# CITY OF ALBUQUERQUE

**Re: Champion Xpress Car Wash**  
**1520 Juan Tabo Blvd. NE**  
**Request for Certificate of Occupancy**  
**Transportation Development Final Inspection**  
Engineer's Stamp dated 01-28-22 (J22-D031)  
Certification dated 08-08-23

Based upon the information provided in your submittal received 08-09-23, Transportation Development cannot approve the release of Certificate of Occupancy for the above referenced project.

APPROVAL FOR
TRAFFIC CIRCULATION LAYOUT
03/10/2022

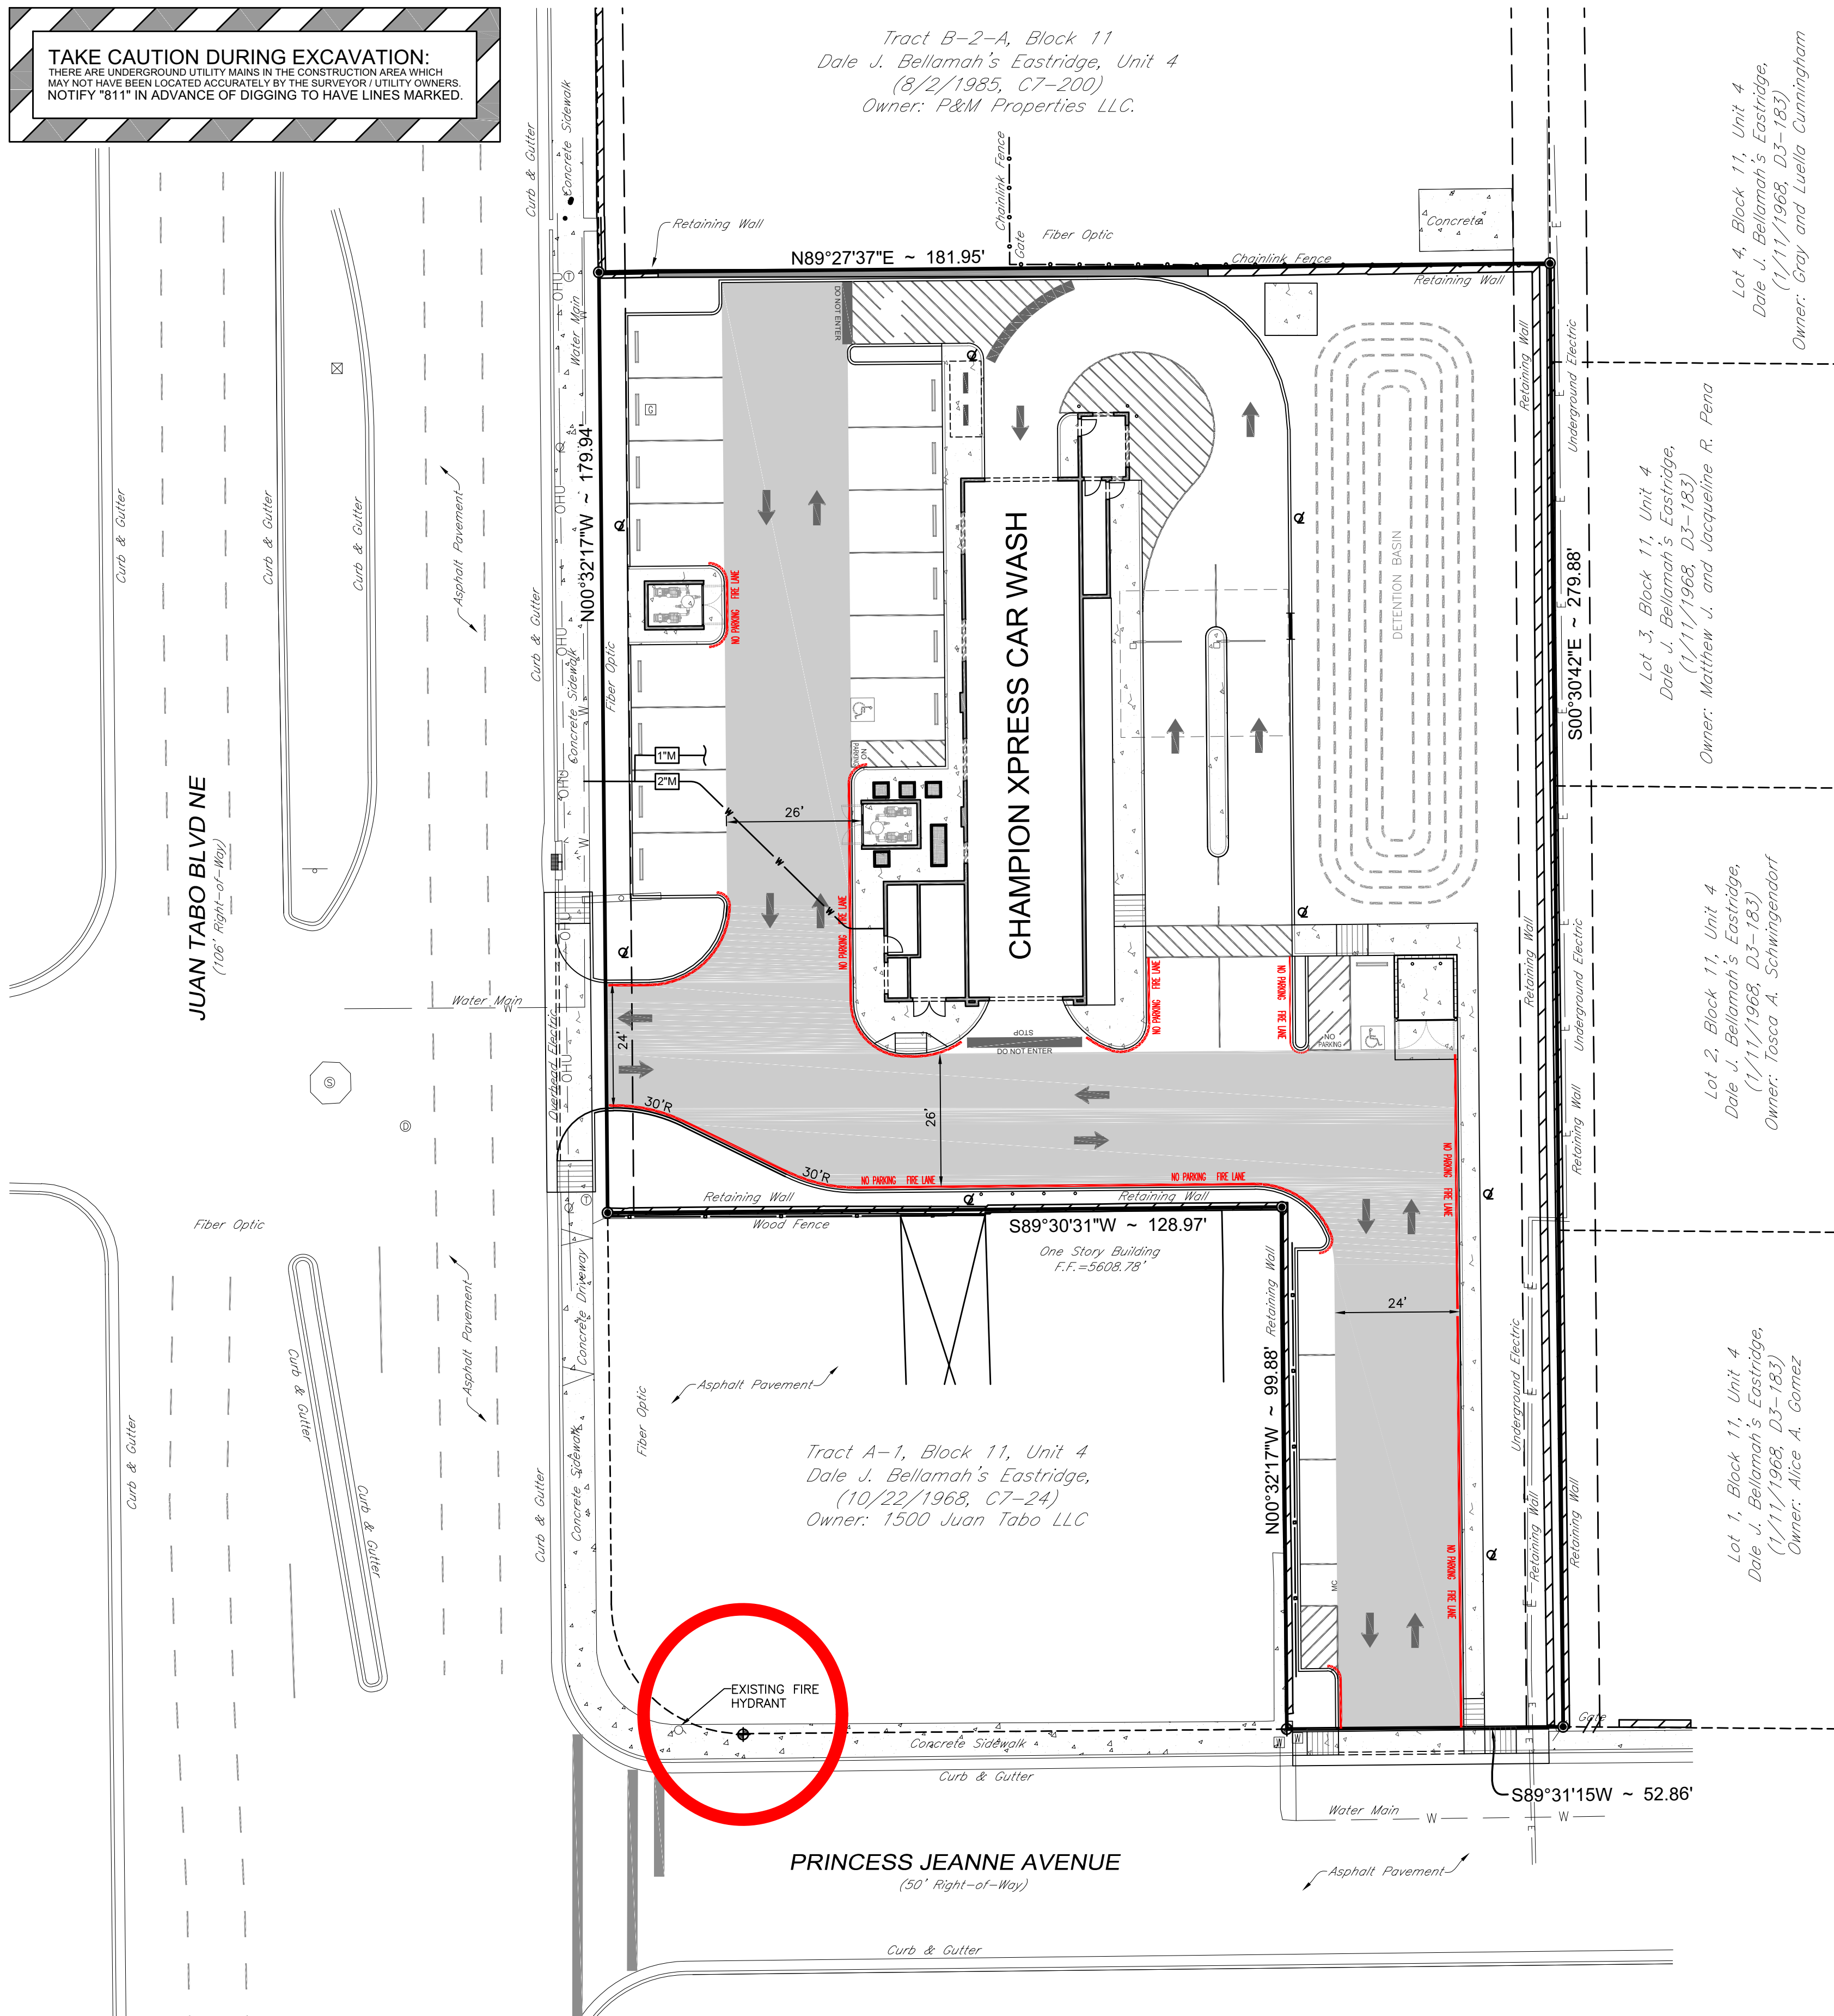
- Site access off Juan Tabo Blvd. must be built per the approved plan.
- Per site visit, the running slope for the east leg ramp of the site access off Princess Jeanne Ave. was 9.2%. Maximum running slope should be 8.2%. please fix this issue.
- The pavement marking "MC" should be shown in the opposite direction for motorcycles entering the parking space.
